Recommendation Report for Planning Permission for Works or Extension to a Dwelling

REF NO: AW/314/19/HH

LOCATION: 17 Frobisher Road
Pagham
PO21 3LT

PROPOSAL: Single storey rear extension and loft conversion to form new 2nd floor with alterations to roof to form gable end and rear dormer projection.

sheet 2 of 3

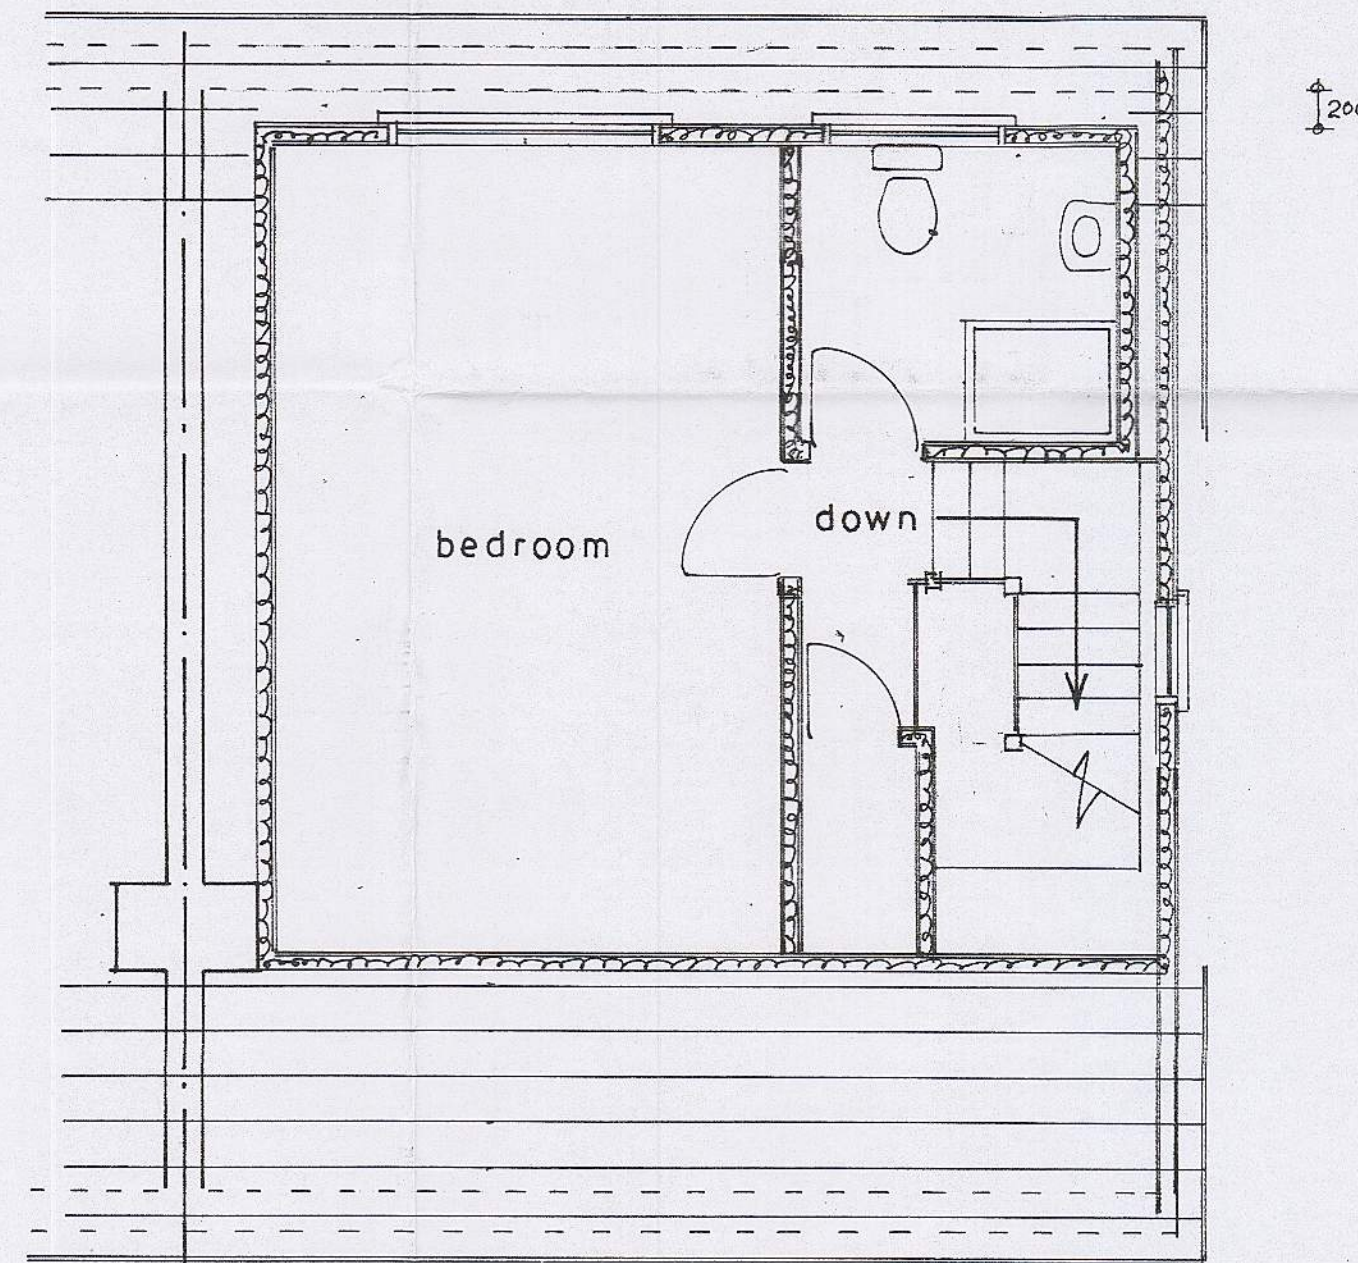
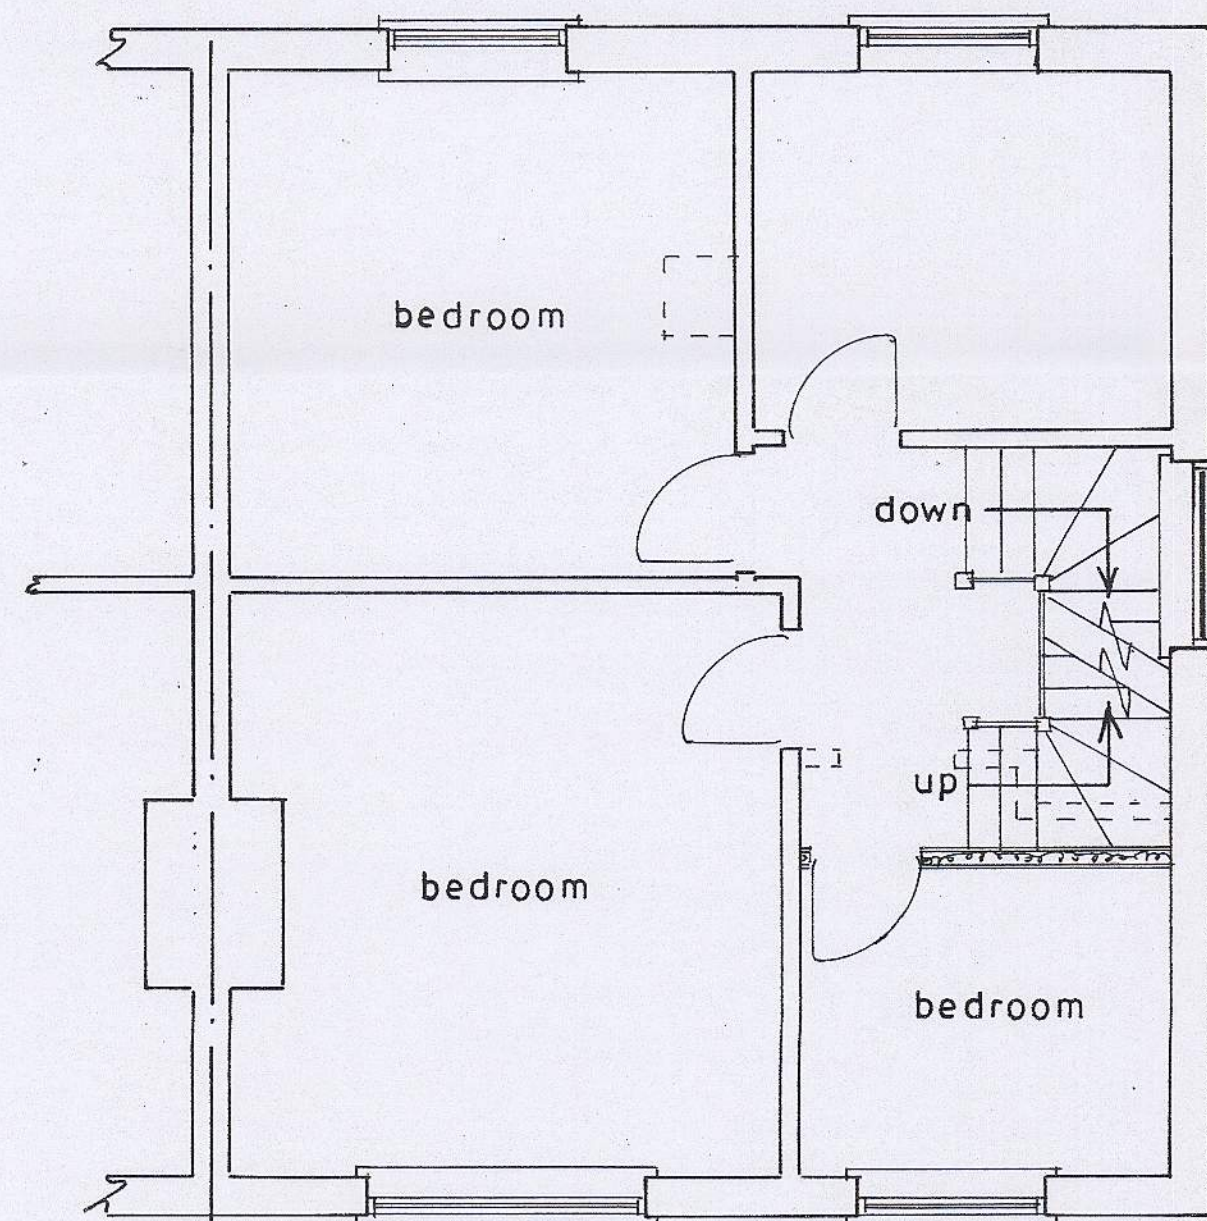
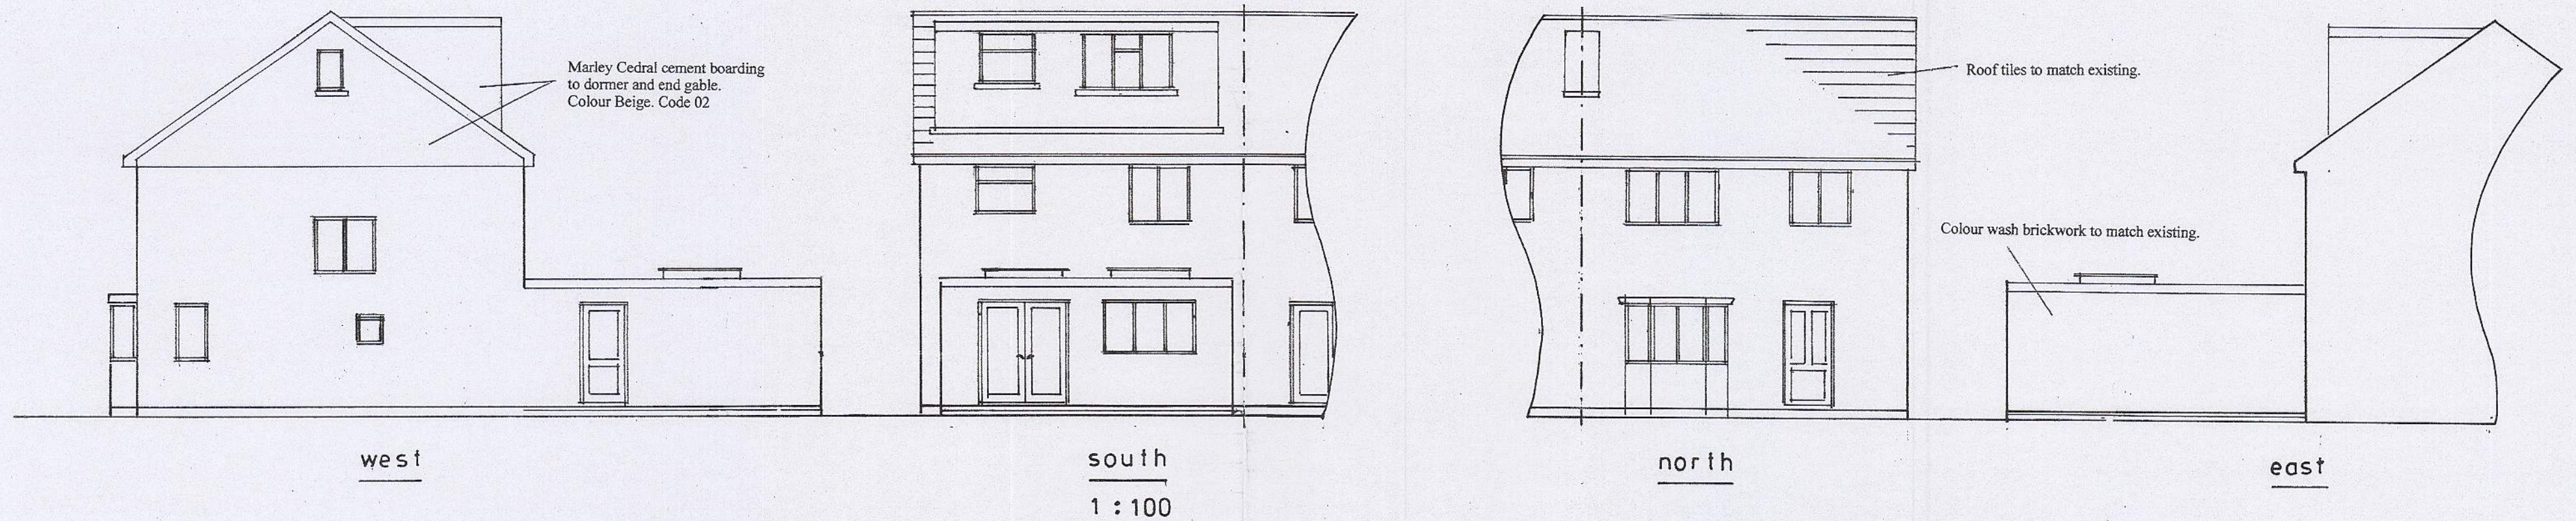
centre and will run the width of the majority of the property. On the northern elevation there is 1 No. proposed set of doors to the rear that are to be the same style as the existing. The proposal includes two roof lights, these are not considered to cause any overlooking by virtue of their location given the proposal looks over the railway line therefore it has no impact on neighbouring amenities.

south
1 : 100

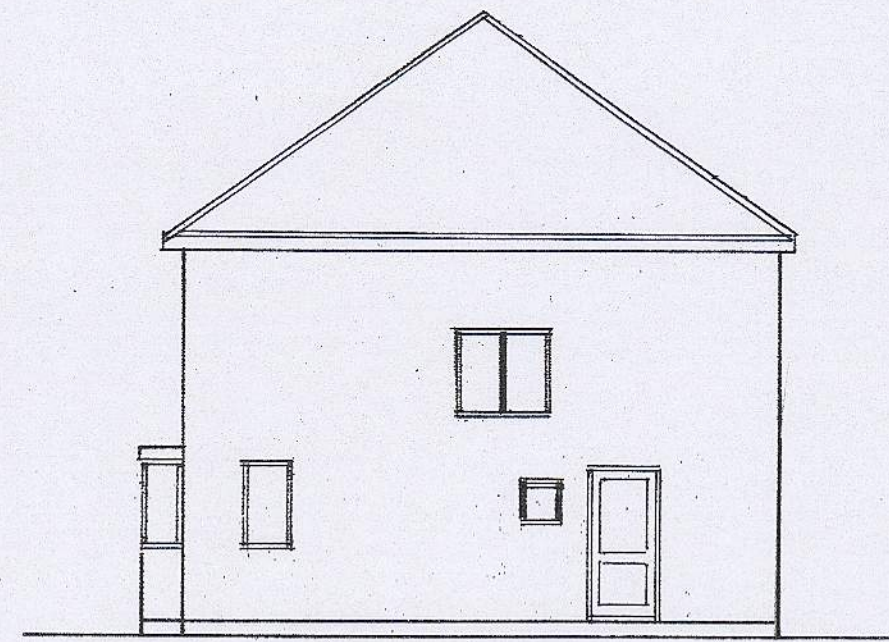
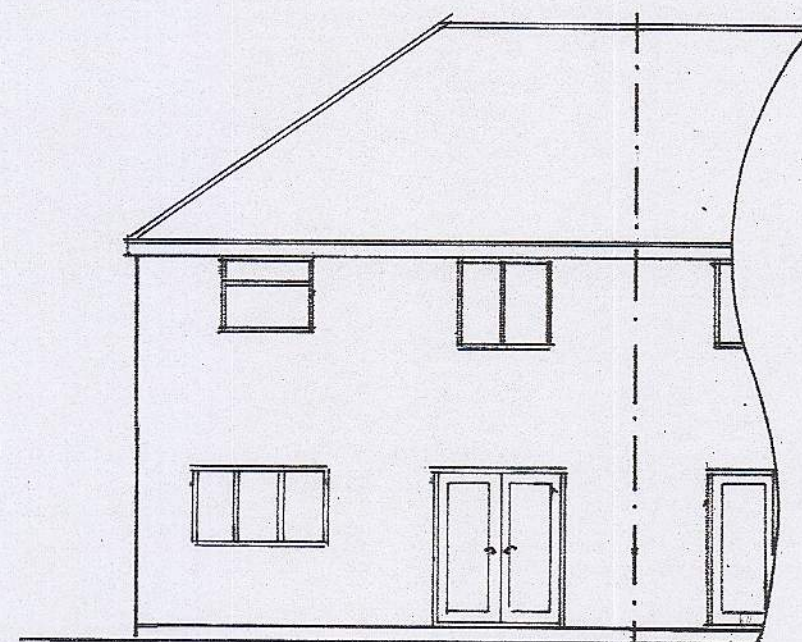
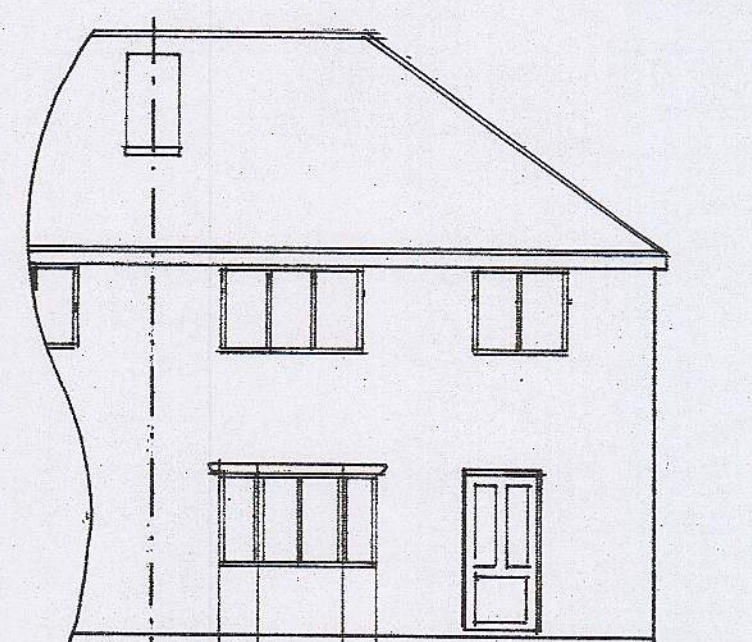
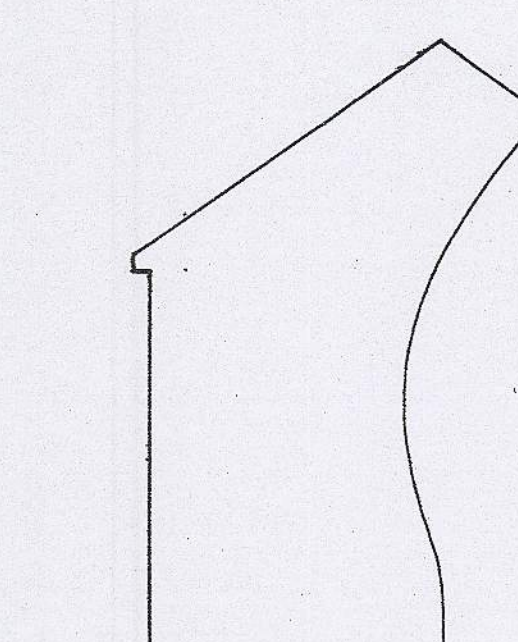
- 3 The bathroom window in the dormer on the Southern elevation shall be obscure glazed and consist of at least two lights divided horizontally with only the top light capable of being opened, and shall be maintained in that condition at all times.
